Ref: A/131/15/RES – Land South of A259 and West of Mill Lane, Rustington; Parish of Angmering

We note the comments made by ADC Parks and Landscapes on 22 October 2015, and Angmering District Council on 23rd October 2015 and have consequently given our Landscaping proposals further consideration.

scheme: Mill Lane Site
client: Store Property
drawing: Landscape Proposals
date: July '15
scale: 1:200@A1
drawing no: STORE18832 18H
drawn: DKM checked: AE

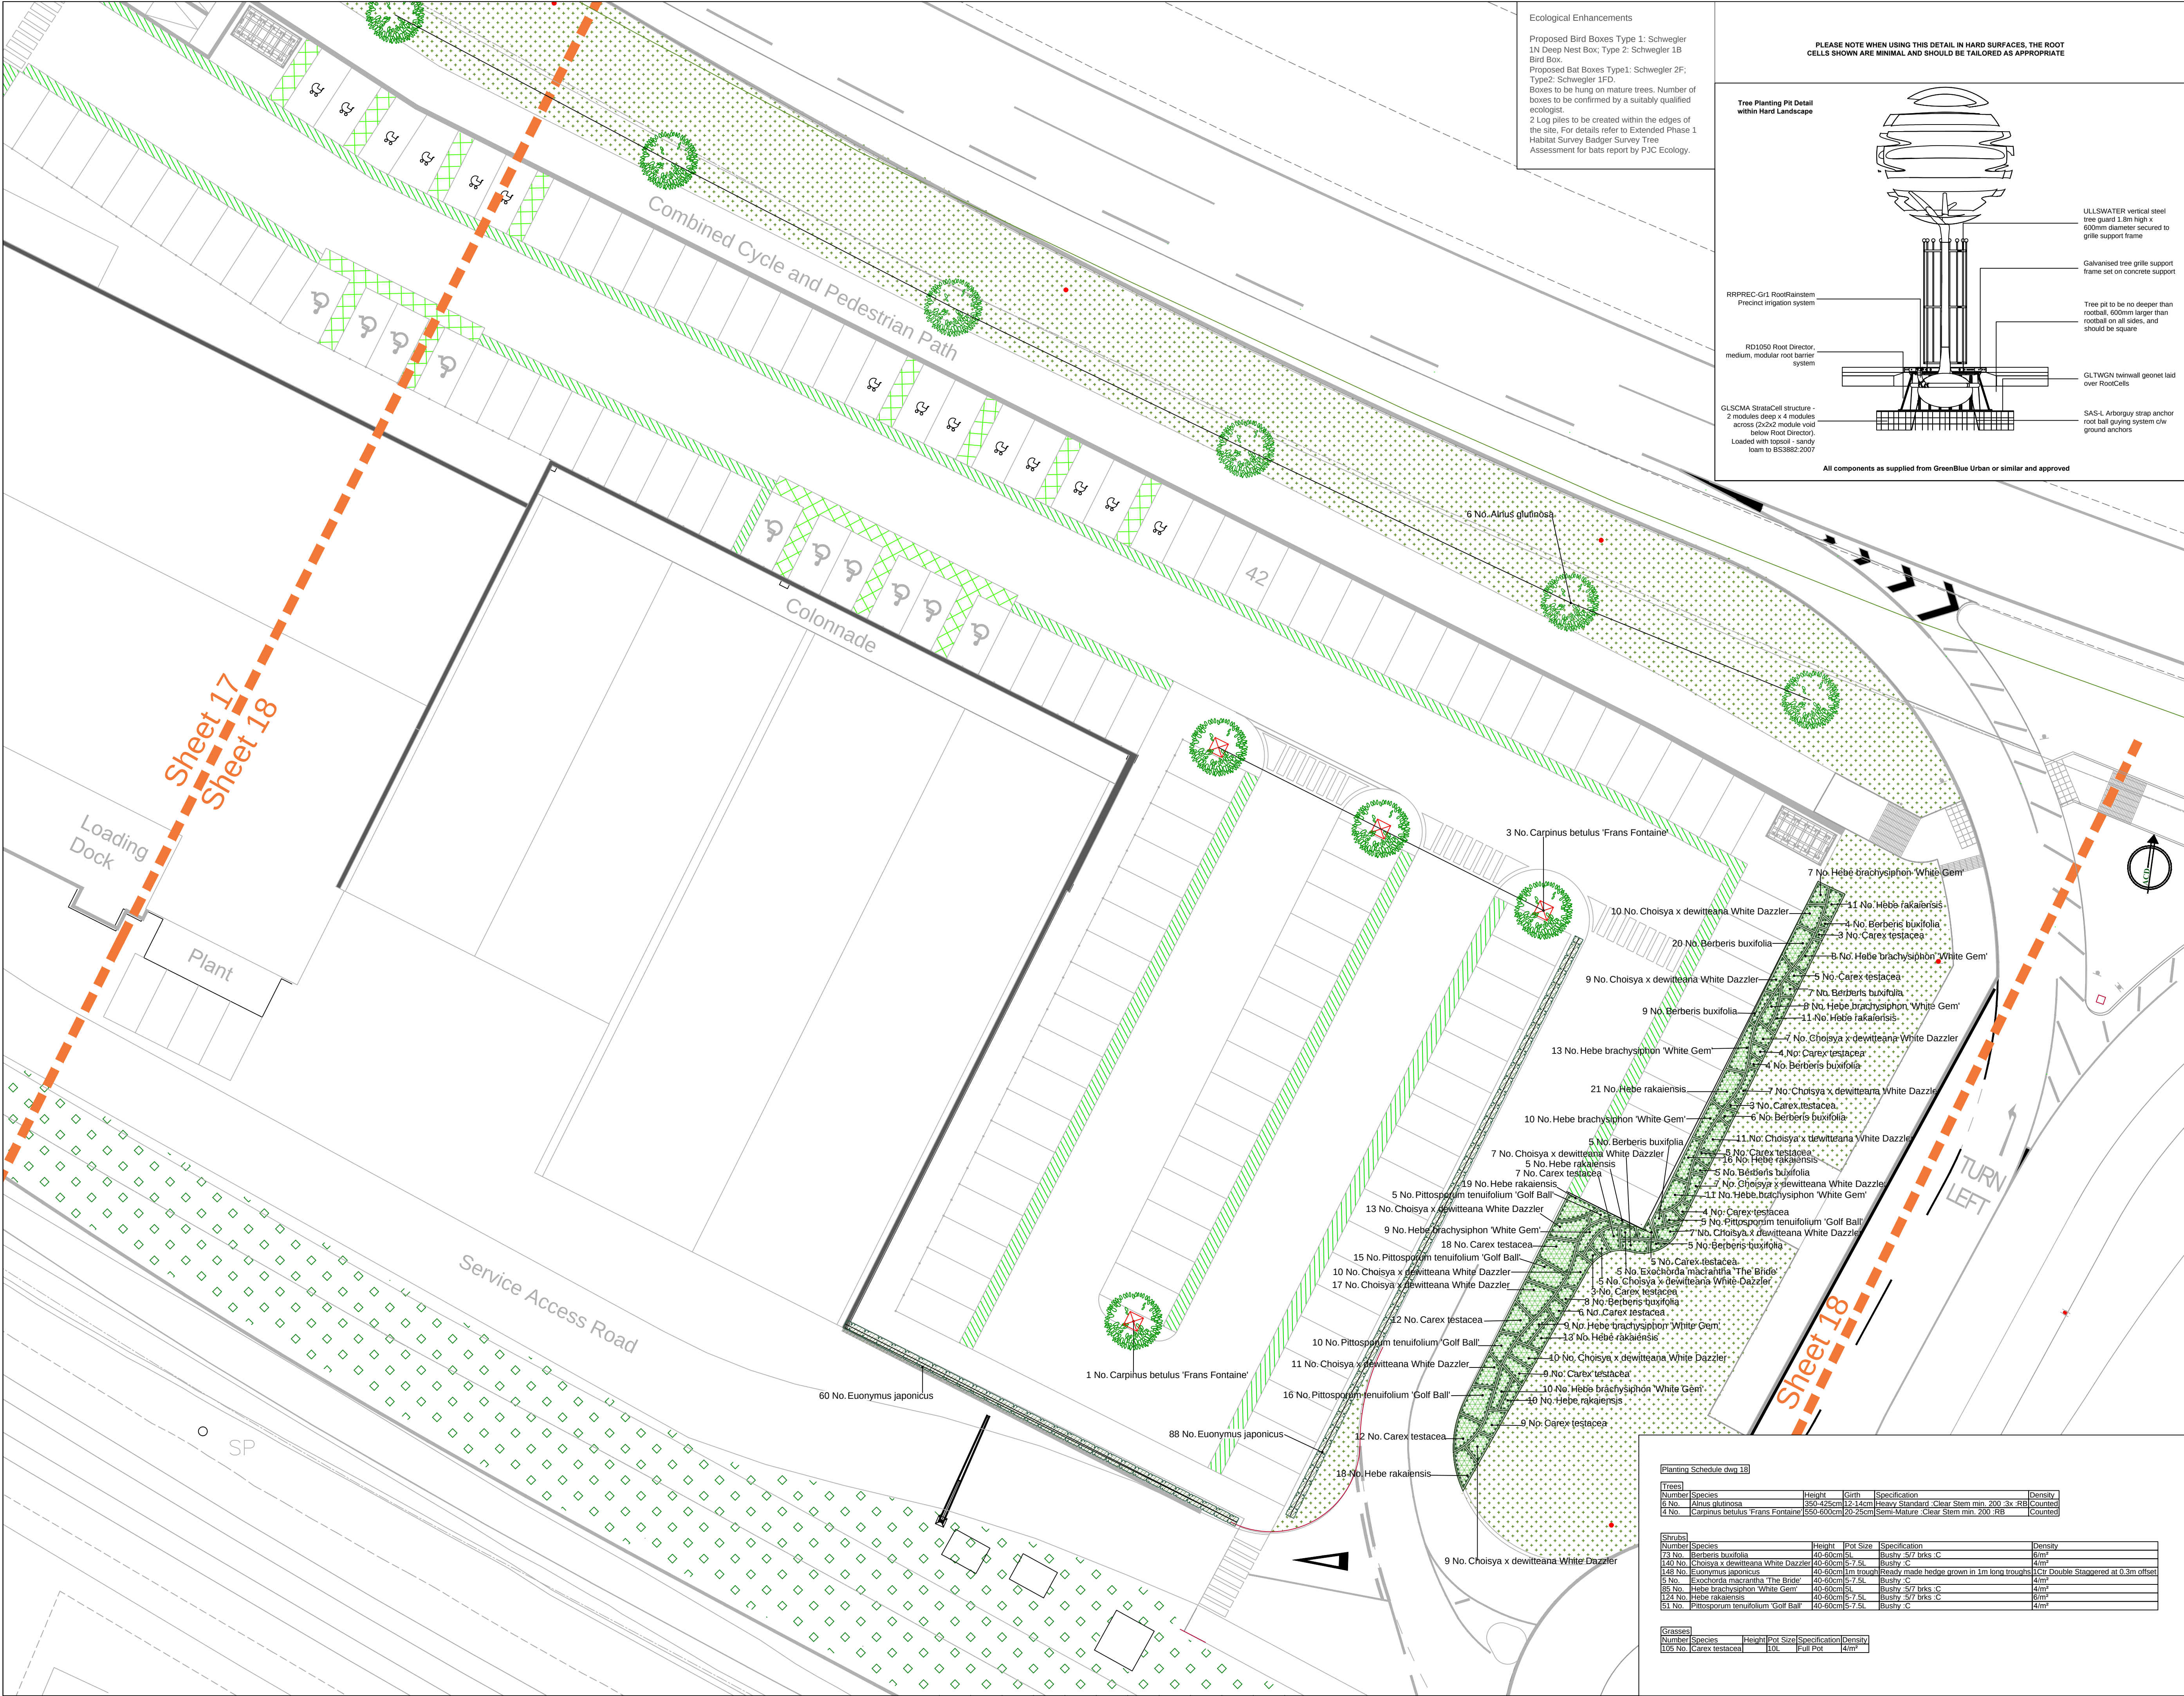
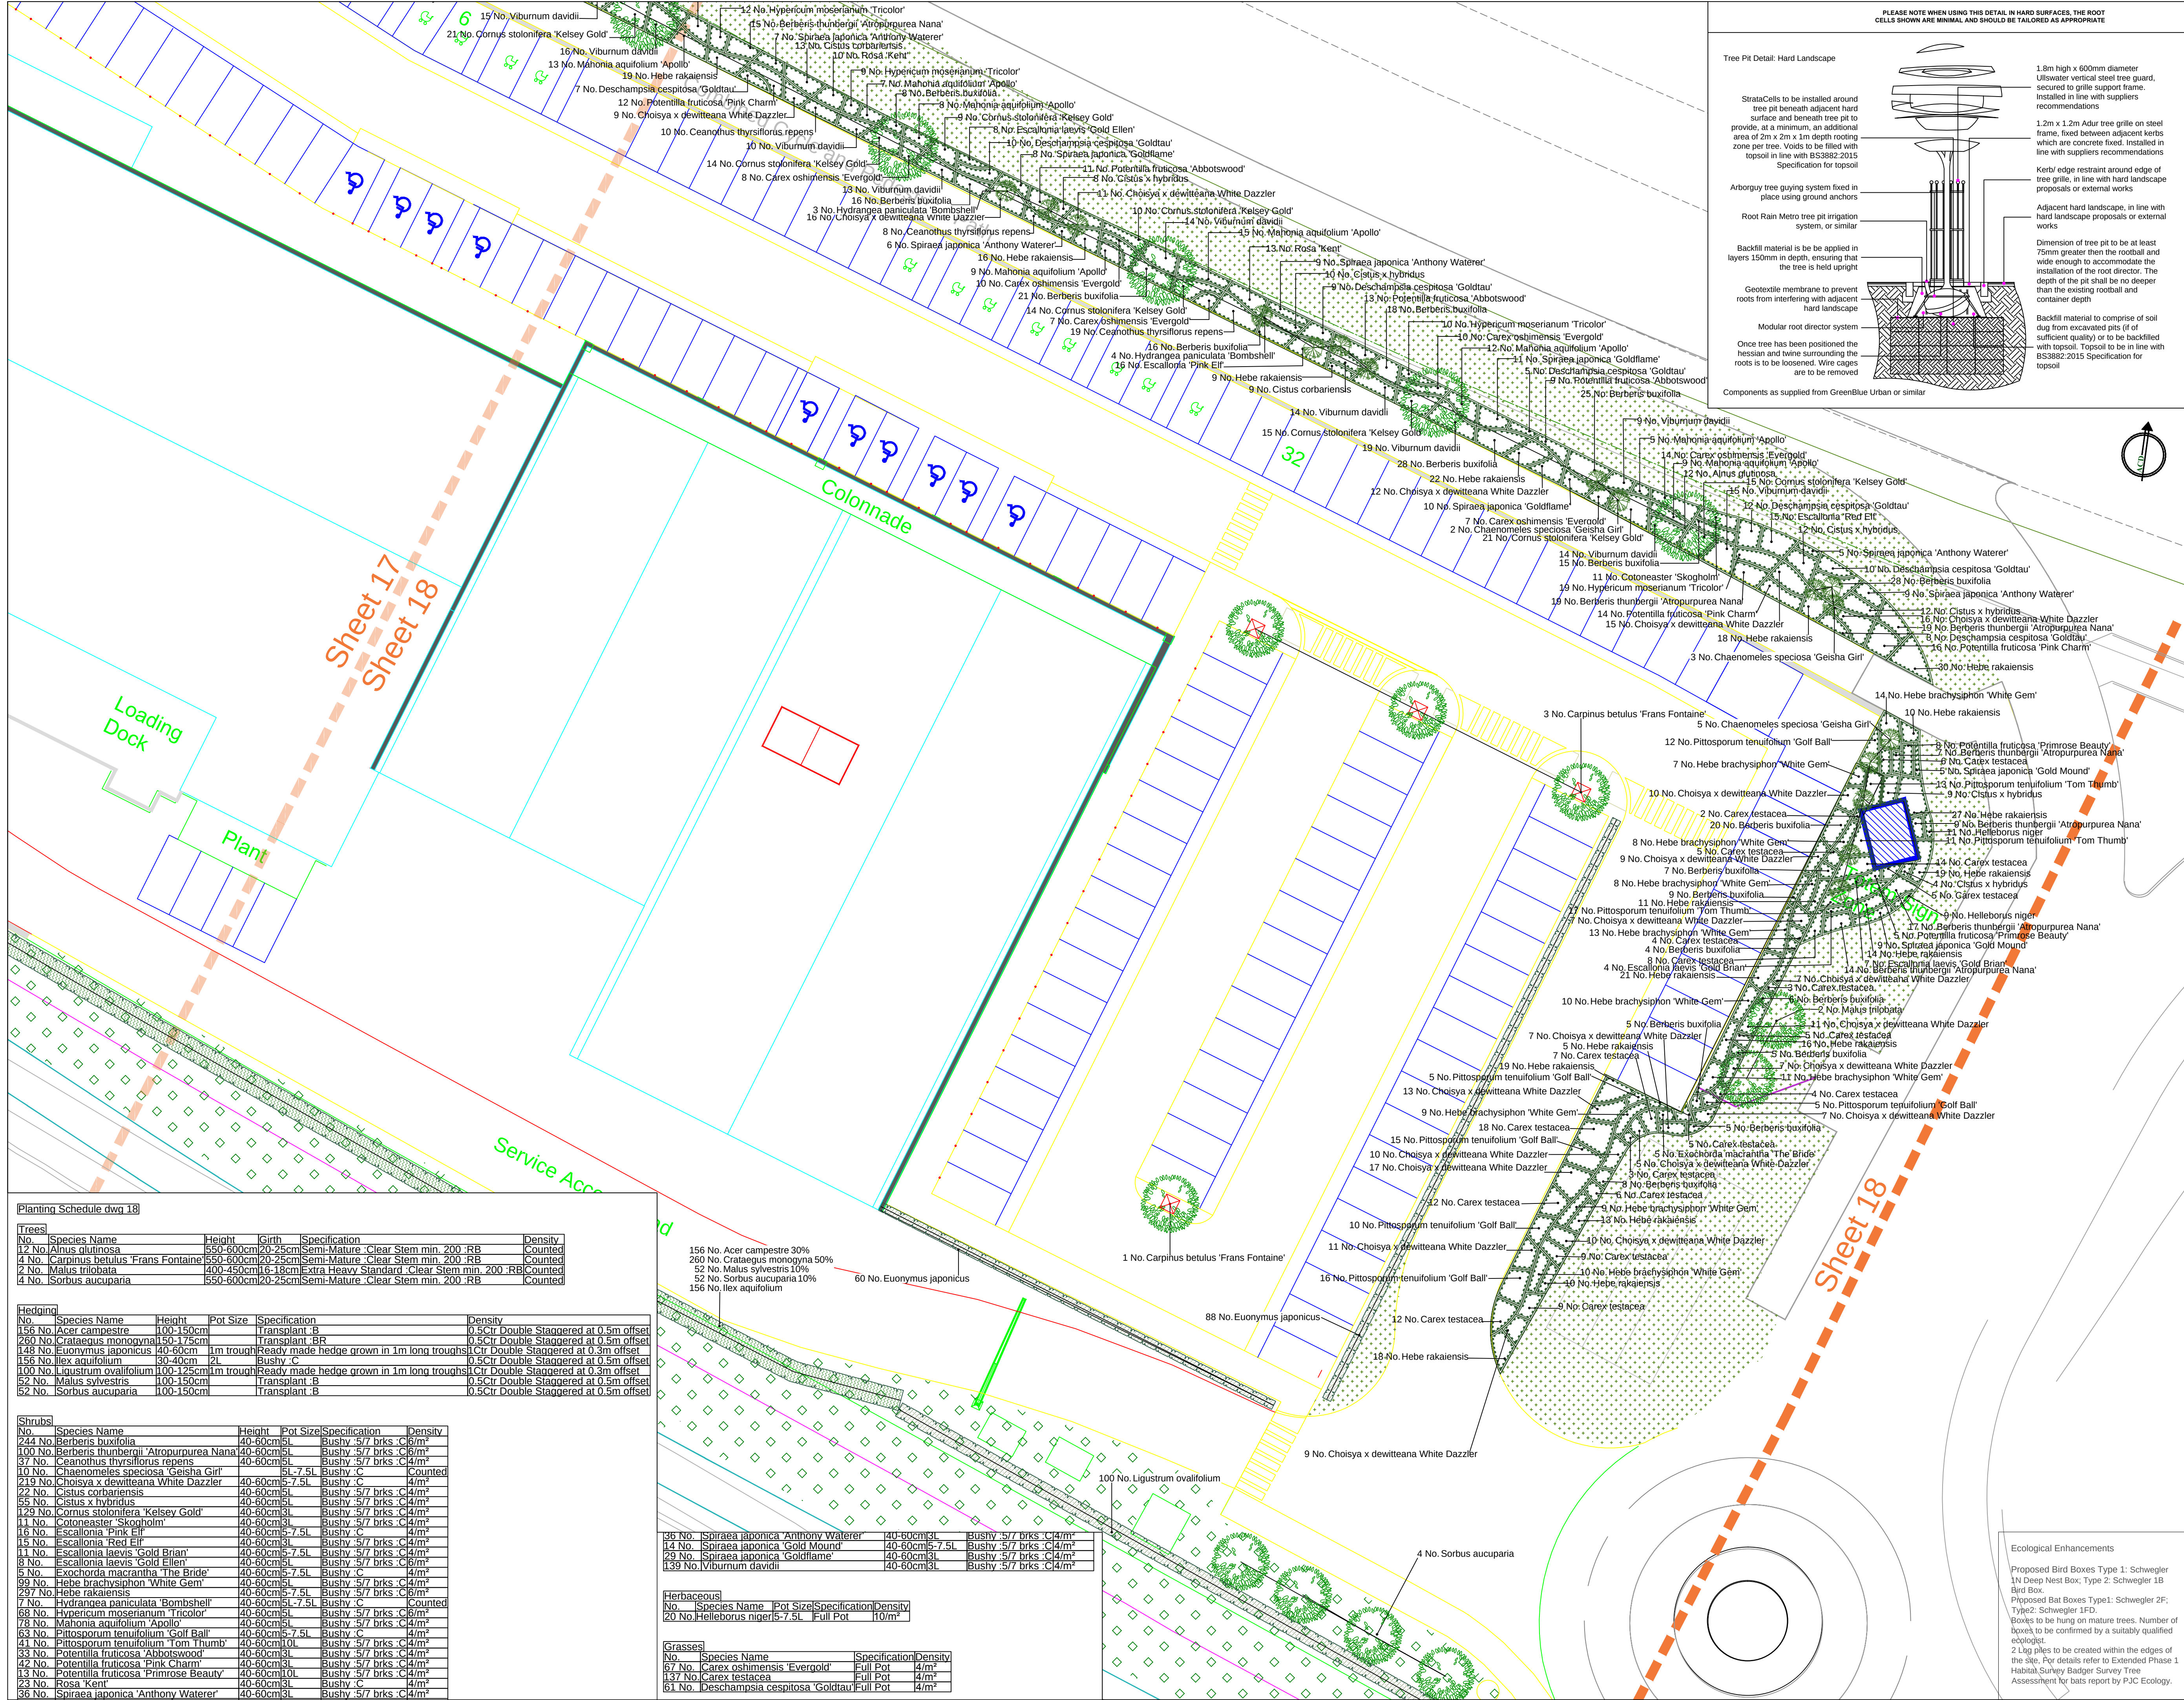
Along the road frontage with the A259, common alders (*Alnus glutinosa*) have been proposed as they provide an attractive frontage with a light and structured canopy. Angmering District Council have observed that we could provide more of these species along the western frontage of the A259 and also the Western boundary of the site, and having considered this further we agree and have consequently shown additional numbers of these species. This will result in a total of 10 *Alnus glutinosa* equally spaced along the road frontage with an additional 4 to be planted within the western landscaping area, providing a total of 14 of these species rather than 9 as originally proposed.

ADC parks and landscapes have expressed concern that the revised landscaping scheme is considerably more sparse particularly on the road frontage and rear areas. The introduction of the additional *Alnus glutinosa* will improve the road frontage and create an attractive frontage to the site.

We note that ADC are also concerned about the number of trees currently proposed overall and as such as well as the additional trees to the northern boundary, we have now significantly increased the number of proposed trees within the western planting area too. These will create an attractive and pleasant environment and additional wildlife habitat. The revised proposal will provide one new tree for each valued tree lost. Native species have been chosen for their biodiversity and wildlife value.
